SUNNICA ENERGY FARM

8.118 Applicant's Response to Other Parties' Deadline 8

Planning Inspectorate Scheme Reference	EN010106
Application Document Reference	EN010106/APP/8.118
Author	Sunnica Energy Farm Project Team

File Name: \\au.aecom.net\com\UK\KCBG\1\005\PR-334327_Sunnica_Energy_Farm\400_Technical\Disciplines\17_GIS\Layout\FR\RA230301_SunnicaEnergyFarm_Figure1_SunnicaEastParameterPlan.mxd

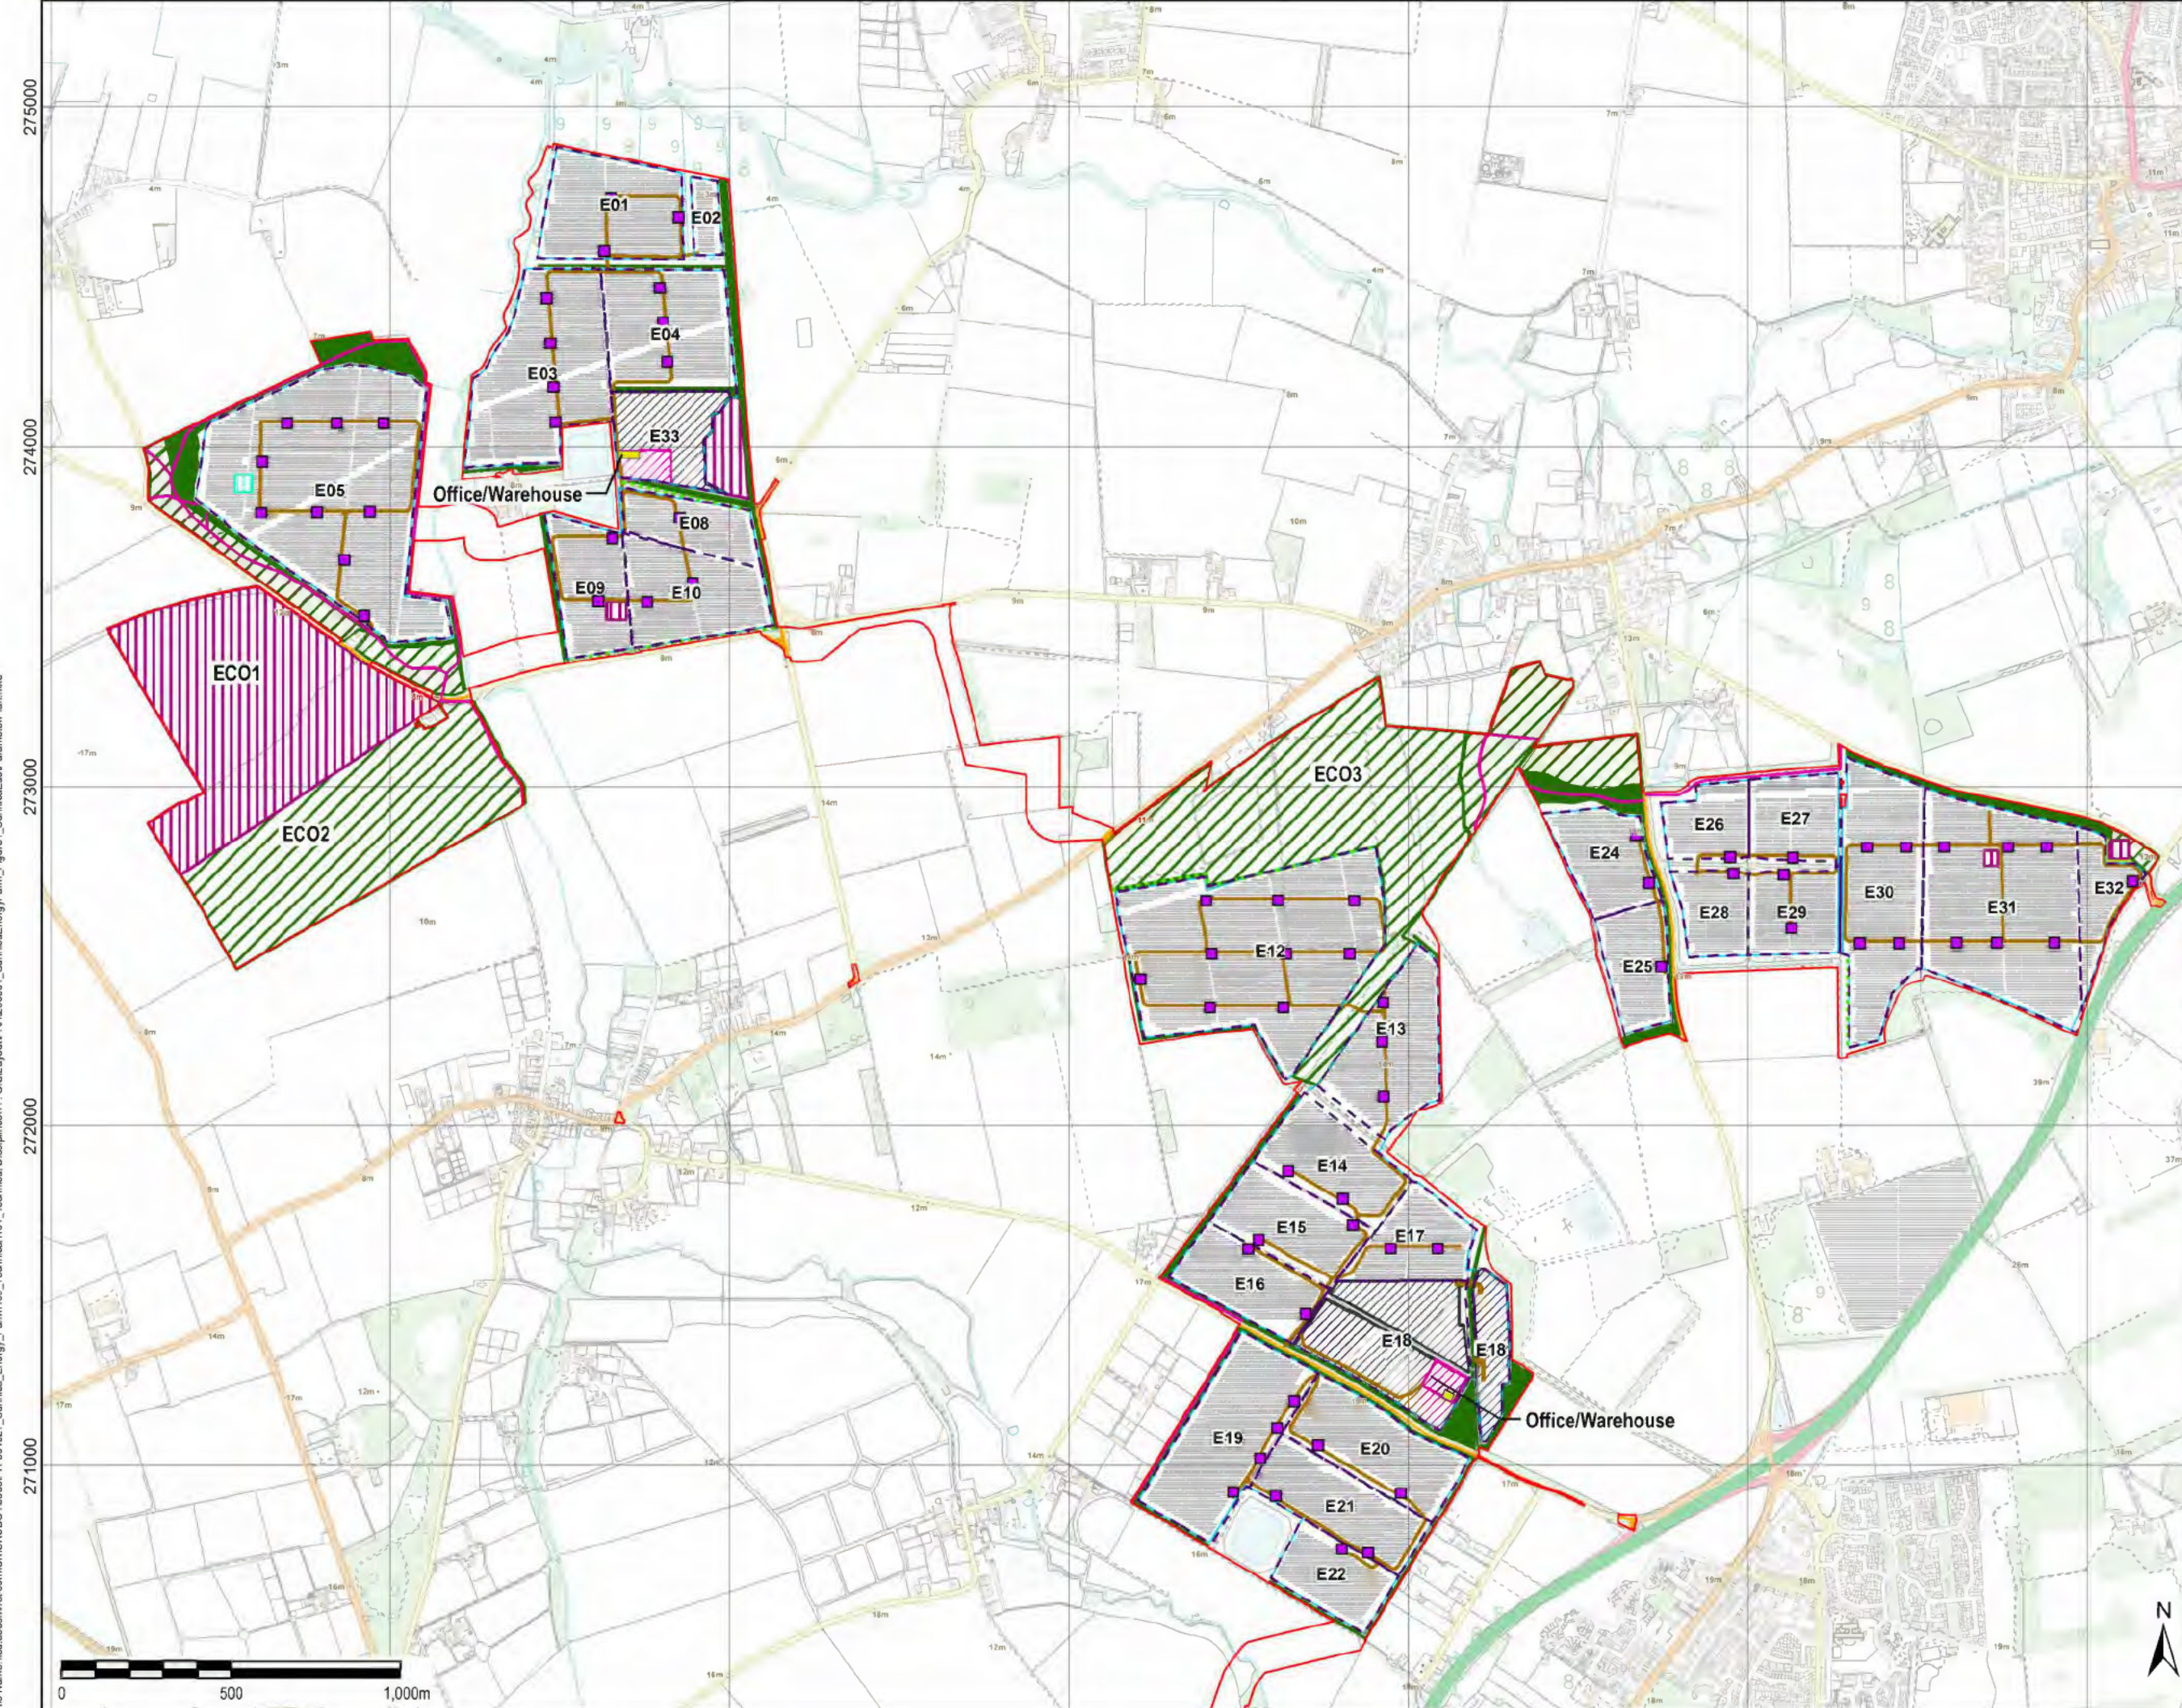
Please explain the significance of "14m" in E13 of the map figure 3-1 Sunnica East Parameter Plan 60589004 and why this is unique to E13	The '14m' is part of the OS Base Mapping and is not related to the Scheme design.
	Worlington Parish Council Deadline 8 Submission [REP8-061] Comments on the U6006	Green Lane/ Badlingham Lane U6006 Worlington Parish Council would like to stress the importance of U6006, contrary to what Sunnica Ltd. have stated. It is a well used track and we believe it is vital to stay as such for the	The Applicant acknowledges the importance of the U6006 to local residents. The U6006 will remain open for the duration of the construction and operational phase of the Scheme, apart from one week during construction.
